Planning Applications Nos 3/2017/0881, 3/2017/0882, 3/2017/0883, 3/2017/0884, 3/2017/0885
Grid Ref: 376260:440124

Proposal : Slurry Tank, Milking Parlour and Farm Buildings

Location : Pendleton Hall Farm Clitheroe Road Pendleton Clitheroe BB7 1PT

Proposed Site Plan with Topo Overlay - 1:500

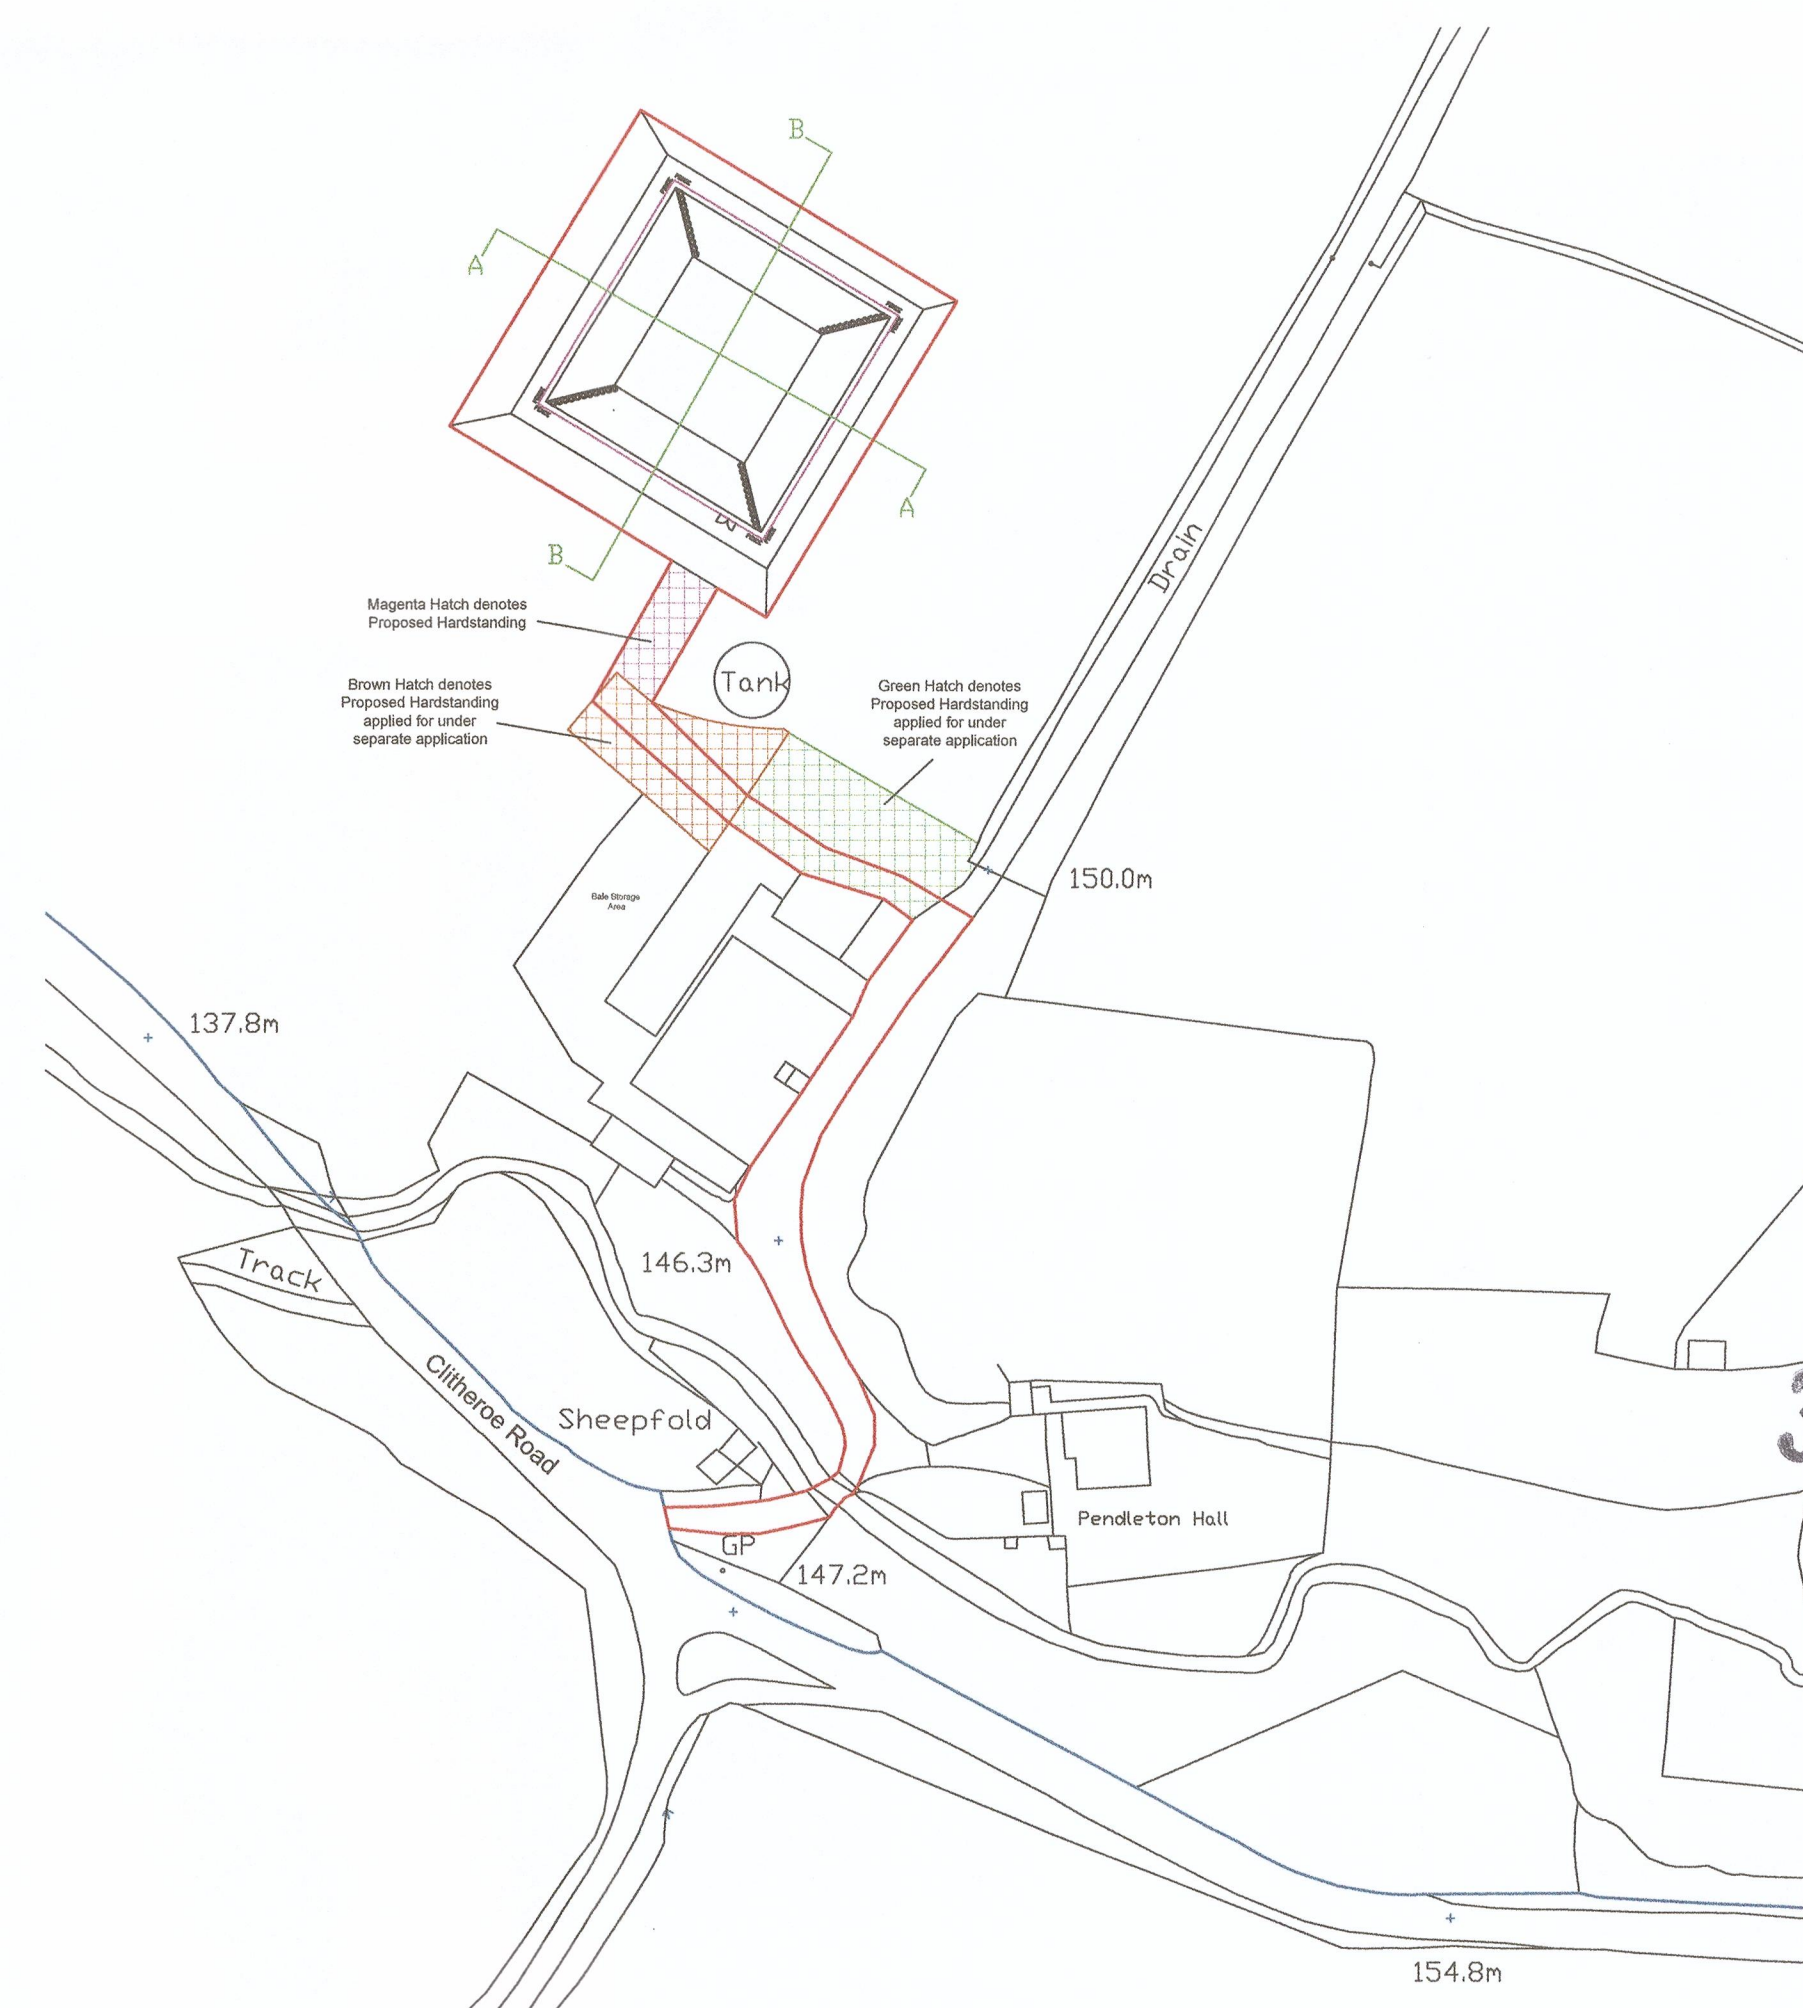
Presently the access road is well orientated for traffic entering the site from the north west (Clitheroe & A59) but the sight lines for leaving the site seem to be restricted. The orientation of the access road would make entering the access road from the south east (Sabden) or leaving the site to head in that direction would be difficult. In addition to this there is a gate that is within 10m of the highway. If this development was to be permitted I would be requesting that there are significant improvements to the access as follows.

1. Any gates are places a minimum of 10m back from the north eastern edge of the highway.
2. That the perimeter walls facing on to the highway are removed or reduced to a height of less than 0.9m to allow sight lines of 152m.
3. There is sufficient space between the gate and the highway for two heavy goods vehicles to pass so that vehicles do not have to wait to enter the access road on Clitheroe Road.
4. The access to Clitheroe Road is re-engineered to allow a left turn from the access road to be completed efficiently and with the drivers being able to see that the manoeuvre is safe.

The improvements listed above are to allow safe access and egress for the access road. The sight line of 152m is what would be requested for a derestricted road working on a speed limit of 60mph. If the developer can prove the 85 percentile speed on the road is less than 60mph then this distance could be reduced, this will have to be provided in the form of readings taken as a result of an automatic traffic count.

1. The junction of the access road with Clitheroe Road, Pendleton is realigned and has been constructed and completed in accordance with the scheme details agreed by the LPA prior to commencement of any one of the planning applications Nos 3/2017/0881, 3/2017/0882, 3/2017/0883, 3/2017/0884, 3/2017/0885.

Such redesign should, as a minimum, provide for the following

- a. Any gates should be set a minimum distance of 10m into the access road
- b. Any gates should open away from the highway, into the access road
- c. The junction should be designed to allow the necessary sightlines for safe access and egress
- d. The access road should be so engineered to ensure that turns both left and right in and out of the access road can be completed in a safe manner
- e. There is sufficient, unobstructed space available for a heavy goods vehicle to pull clear of the highway and wait before proceeding along the access road.

2. On completion of the remodelled access, that part of the access extending from the highway boundary for a minimum distance of 10m into the site shall be appropriately paved in tarmacadam, concrete, block pavements, or other approved materials. Reason: To prevent loose surface material from being carried on to the public highway thus causing a potential source of danger to other road users.
3. No part of the developments hereby approved shall commence until a scheme for the construction of the site access and the off-site works of highway improvement has been submitted to, and approved by, the Local Planning Authority in consultation with the Highway Authority. Reason: In order to satisfy the Local Planning Authority and Highway Authority that the final details of the highway scheme/works are acceptable before work commences on site.
